**KIRKLEES METROPOLITAN COUNCIL  
INVESTMENT & REGENERATION SERVICE**

**DELEGATED DECISION TO DETERMINE PLANNING APPLICATIONS**

Reference No:	<b>2025/62/91736/W</b>
Site Address:	Long Ing Banks Farm, Long Ing Road, Hade Edge, Holmfirth, HD9 2TG
Description:	Erection of agricultural (livestock) building
Recommending Officer:	Danielle Cooper

Proposed Block Plan

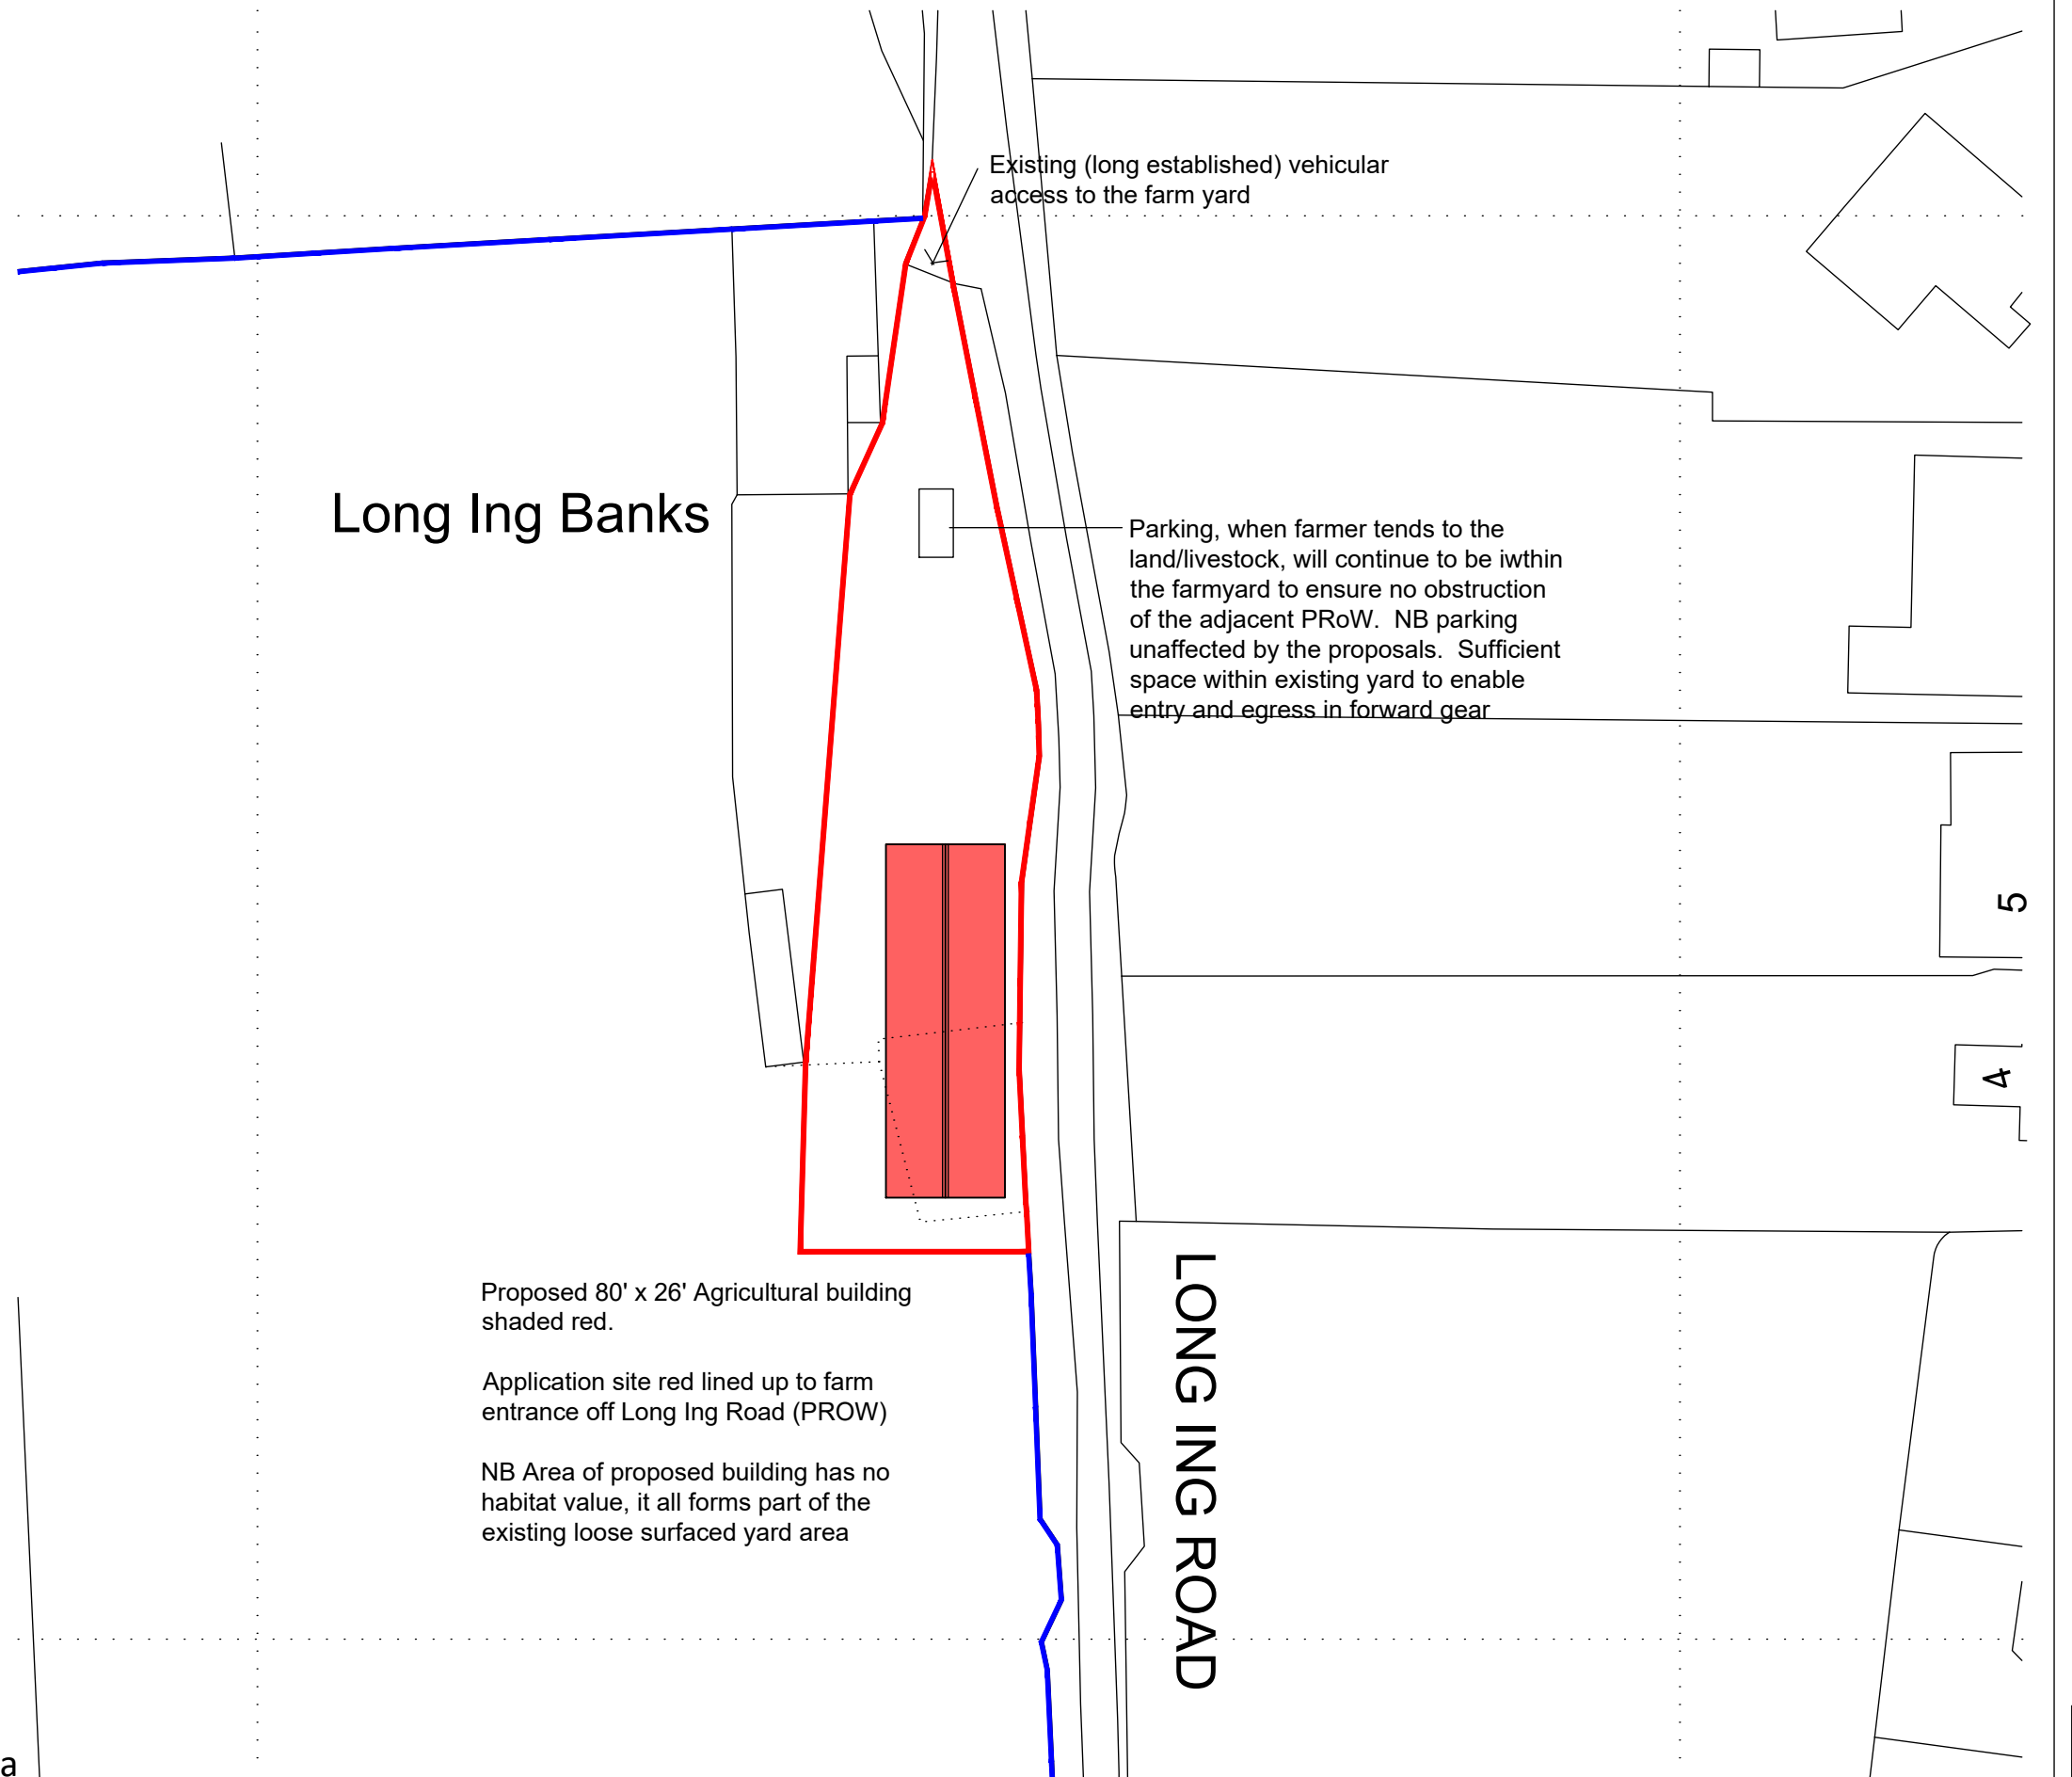
The proposed block plan was revised to indicate how the site will be accessed. Sample materials were also provided via email.

The proposal would involve no changes to the access and no removal of parking areas as shown on the proposed block plan. The proposed agricultural building would accommodate lambs and as such it is not expected that any additional vehicle trips will occur on the highway during the operation of the site. If there were to be an intensification, officers consider this would not be to such a significant degree as to have a severe impact on the operation or efficiency of the local highway network. As such, officers consider the application to be acceptable on highways grounds.

- The existing dry-stone wall is not shown on the submitted plans
- The existing dry-stone wall has been replaced with fencing which does not keep in character with the green belt setting.

*Officer comment: It is not considered necessary to include the existing stone wall on plan. It is noted that fencing and wiring have been erected along the site boundary next to the existing track. However, the proposed fencing does not require planning permission given its modest height. The agent has also confirmed that the fencing and wiring was erected to stop dog attacks on the livestock on the site. It also considered that the proposed fencing and wiring, which is not close boarded, ensures the openness of the green belt setting is maintained.*
